Inspector's Report ABP-306204-19

Development	Development consisting of a new 110kV substation, underground 110kV cabling and ancillary works to connect the already consented Upperchurch Windfarm substation to the existing 110kV overhead line.
Location	Mountphilips, County Tipperary
Planning Authority	Tipperary County Council
Applicant(s)	Ecopower Developments Ltd.
Type of Application	Application under the provisions of Section 182A of the Planning and Development Act, 2000 (as amended)
Observer(s)	<ol style="list-style-type: none">1. Irish Water2. Transport Infrastructure Ireland3. Rear Cross Tidy Towns Committee4. Emer Ó'Siochrú & Toal Ó'Muiré5. Tipperary County Council (c/o James Hayes)6. Ned & Carmel Buckley

Figure 6: Option 1, raising the parapet by build-up of masonry in same style stone or Option 2, raising the parapet by build-up of masonry in deliberately different stone

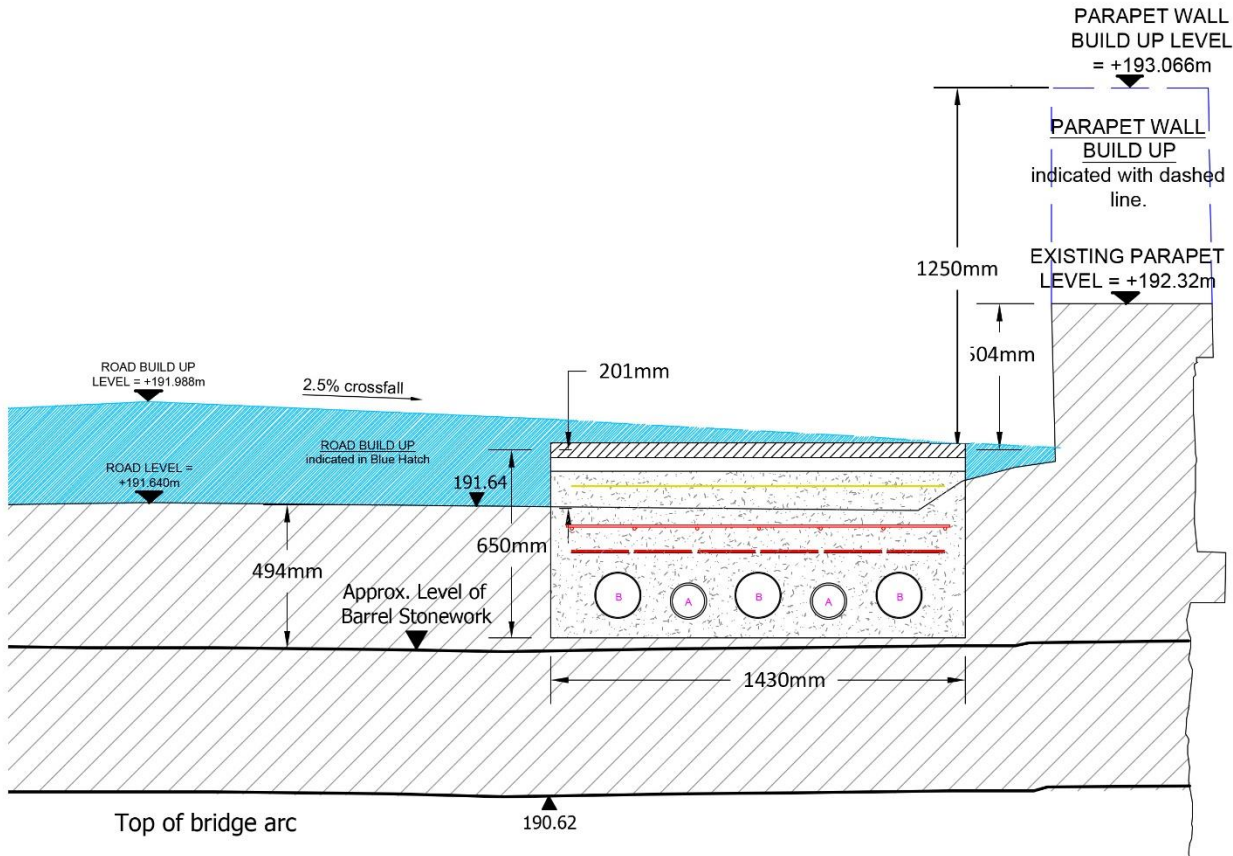
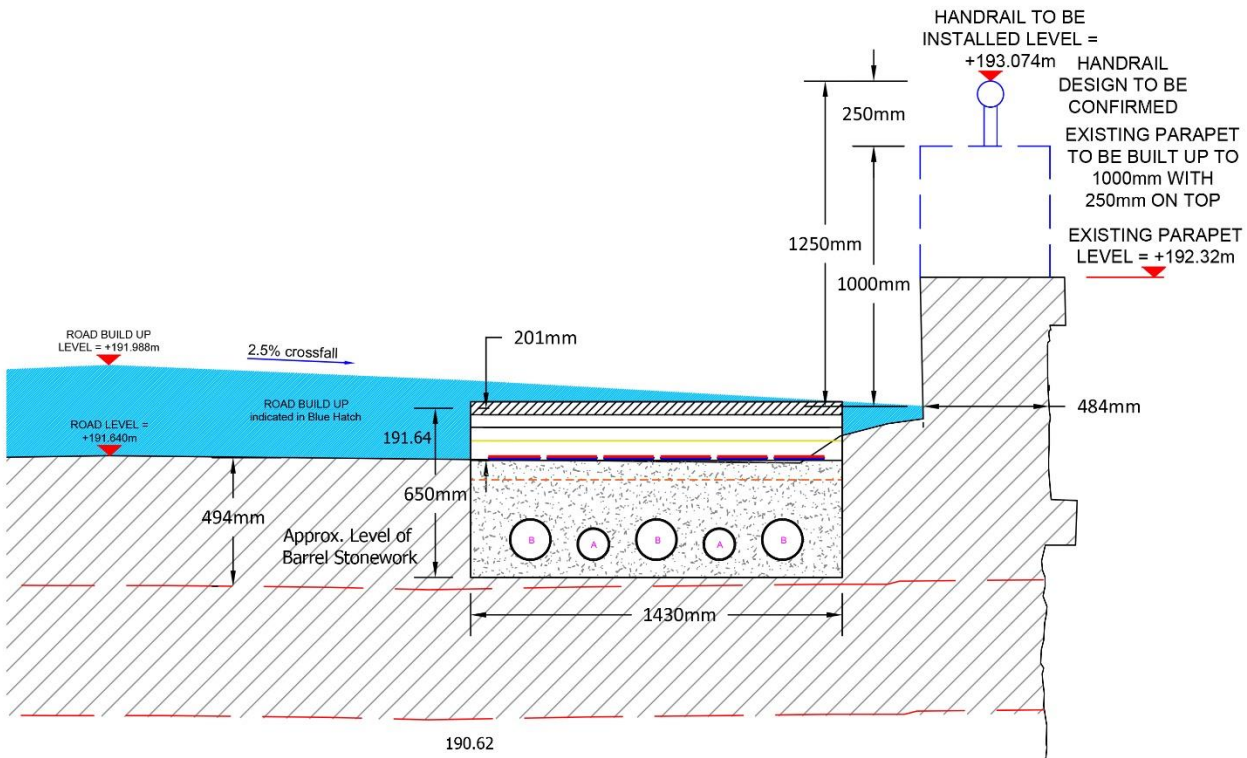
- No Architectural Heritage Impact Assessment (AHIA) has been prepared for Torreenbrien Bridge (RPS Ref: S801) – works proposed to raise parapet walls. AHIA prepared for Anglesey Bridge.
